Contact: Kate MacDonald
Phone: 02 9228 6435
Fax: 02 9228 6540
Email: kate.macdonald@planning.nsw.gov.au
Our ref: MP10_0171 MOD 3

330 Church Street, Parramatta (MP10_0171 MOD 4)

Attachment 1

SHADOW DIAGRAM - WINTER SOLSTICE (JUNE 21ST) 3.00PM
1:2000 @ A1

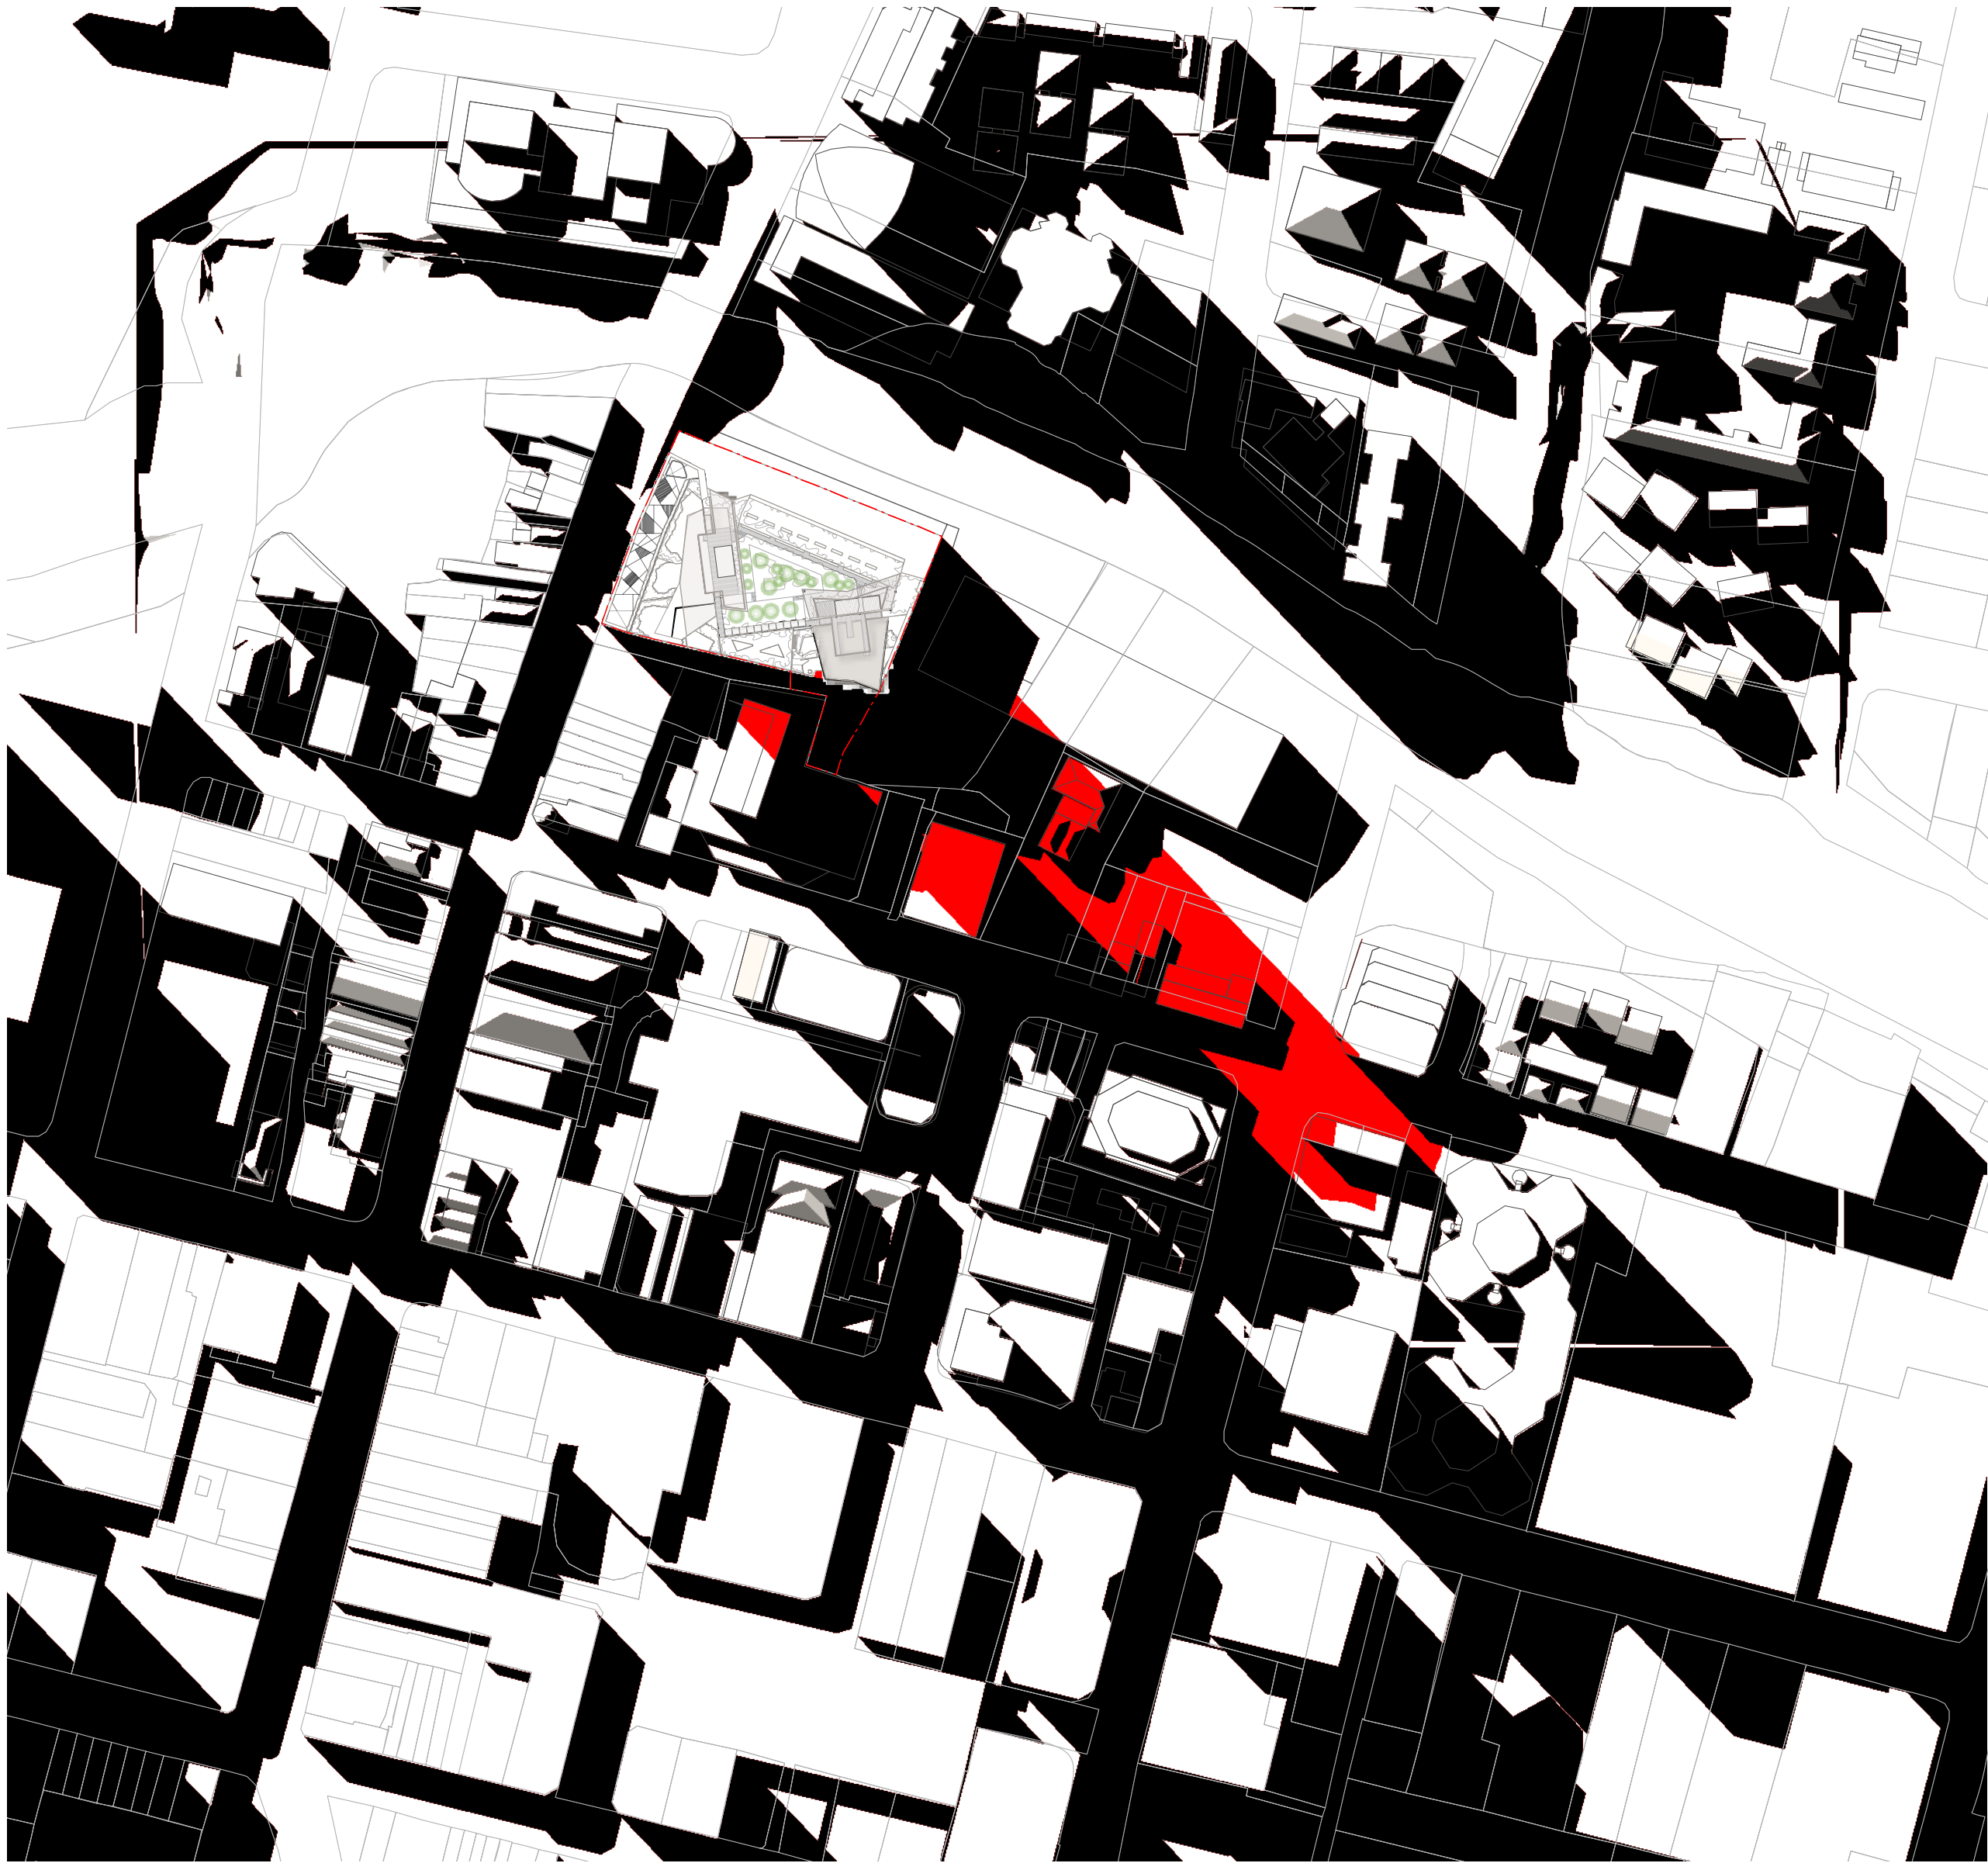
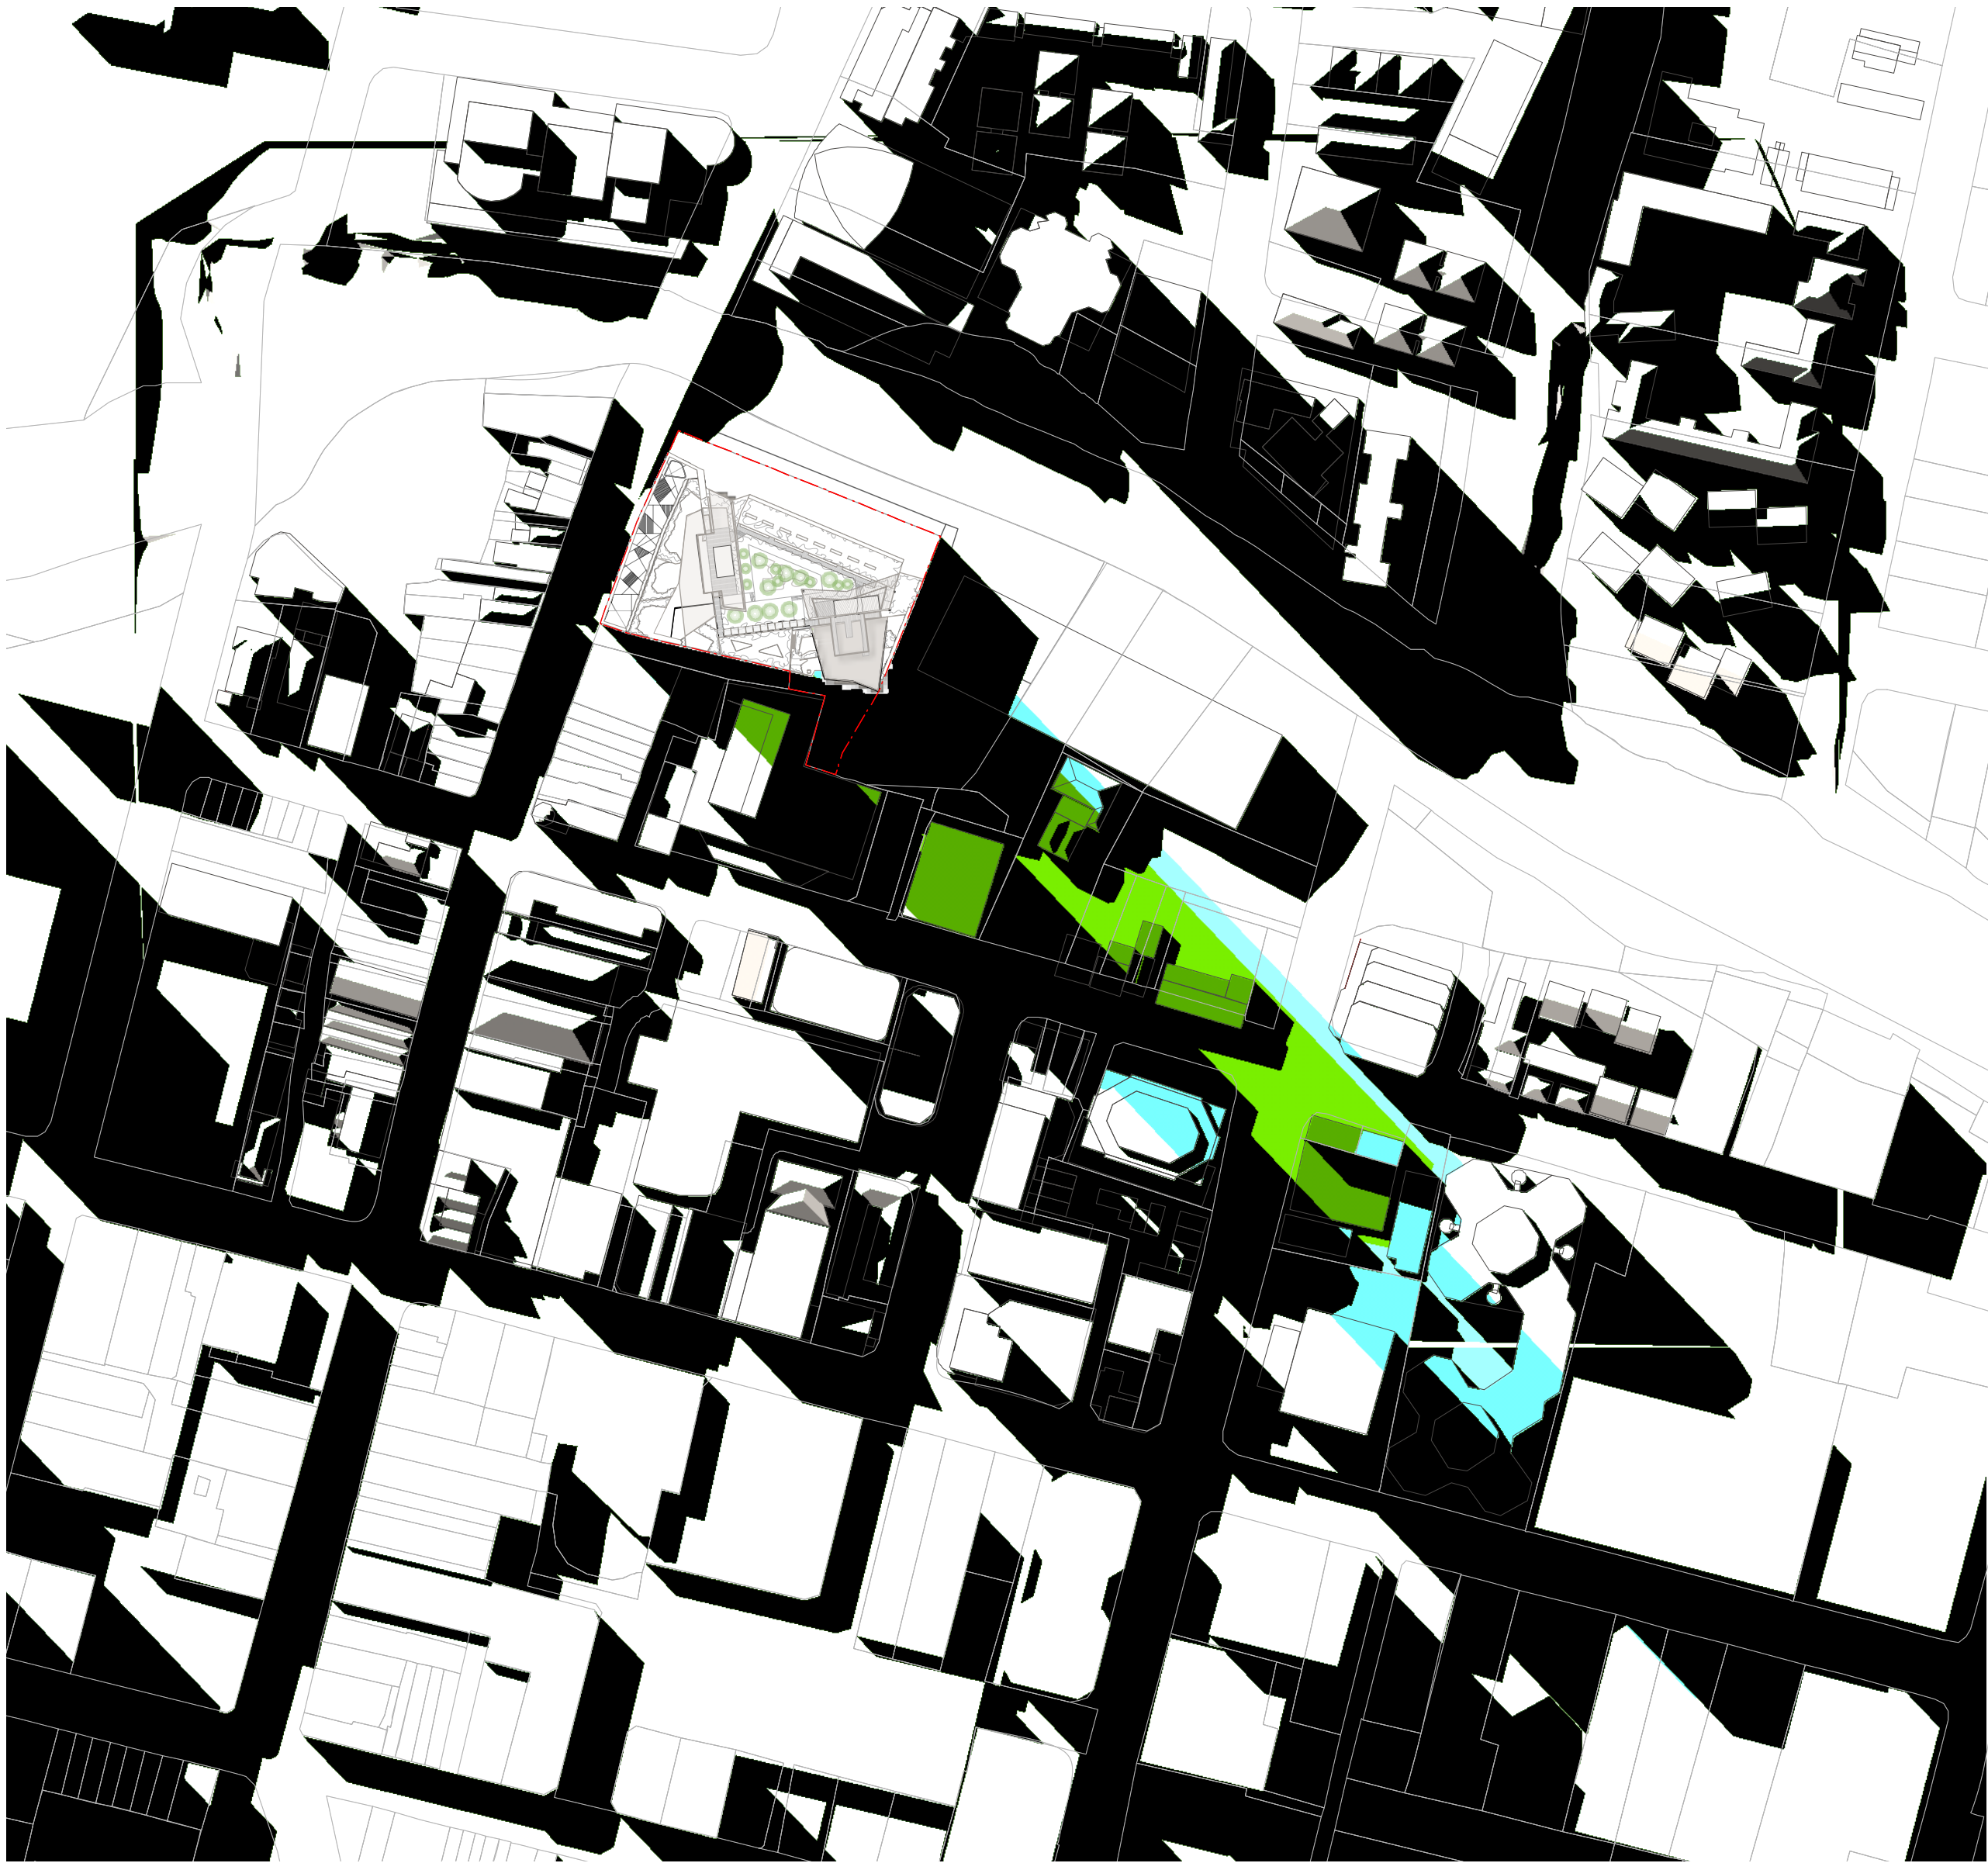
The shadow diagrams must be revised to reflect any revisions to the proposed building.
